Consultation Response from KC Highways		
2019/90155 Former Harrisons Electrical Warehouse, Huddersfield Road, Dewsbury, WF13 2RU		
Change of Use and alterations to convert trade counter retail unit to function room		
Date Responded: 09/12/19	Responding Officer: CNB	Responding Ref: K15-2NW/40
POST DEFERRAL FURTHER INFORMATION RESPONSE This response is based on further information submitted by the applicant after a meeting at Kirklees planning offices on 4/11/19 and after the application was deferred at committee for further information relating to highways issues and should be read in conjunction with the previous highways responses, amended below. These comments refer to Technical Note 4: Highways and Parking/Event Management Plan by VIA Solutions and drawing No 1816203a Proposed Car Park Layout. The initial highways concern was that the impact of the proposals on the operation of the local highway network and highway safety could not be assessed as there were no trip generation figures provided with the application to indicate the vehicular demand that the development would create. There are no trip generation figures for this type of land use on the national TRICS database, the i

PROPOSED CAR PARK LAYOUT

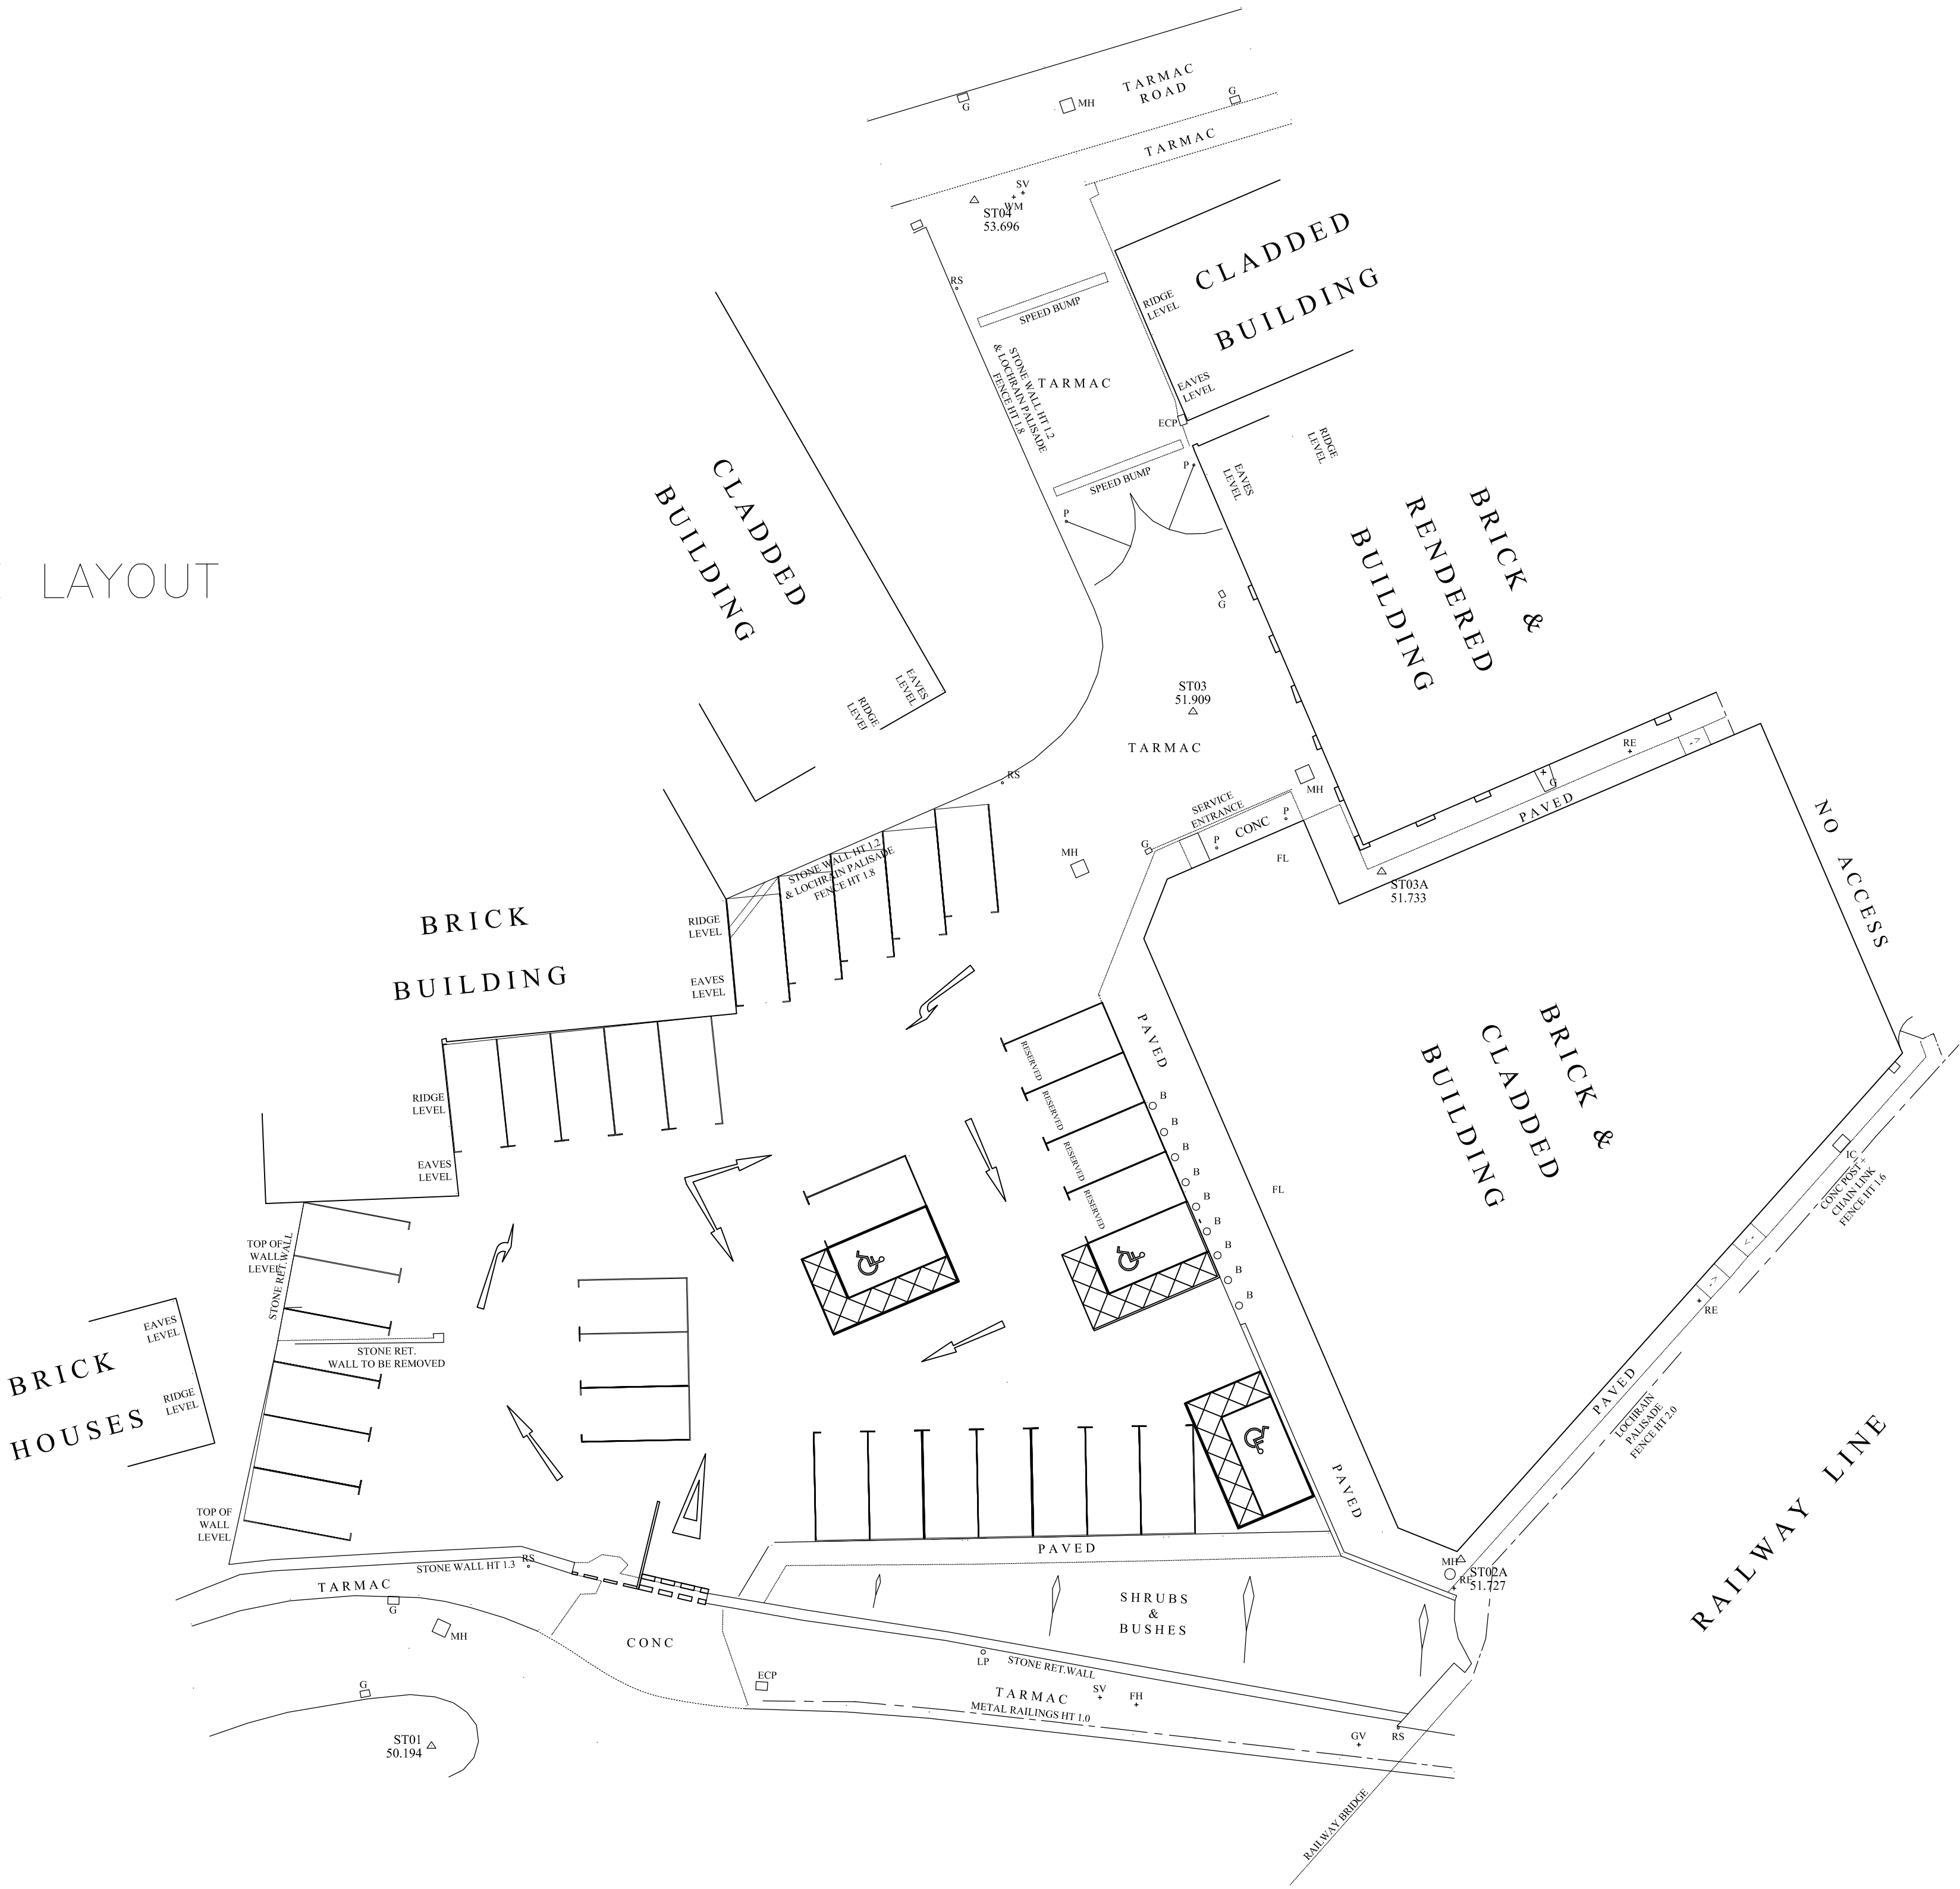
Drawing No 1816203a Proposed Car Park Layout shows a dedicated drop off point and this is acceptable as it still allows access to the allocated car park spaces. A swept path shows that a “stretch limo” type vehicle can also access the site safely.

A separate pedestrian access should also be shown to the paved pedestrian link across the car park. Ideally this paved footway should be 2m wide and not 1m wide as shown and should have a kerb or bollards to the edge against the vehicle parking spaces to stop vehicles mounting the footway for safety reasons.
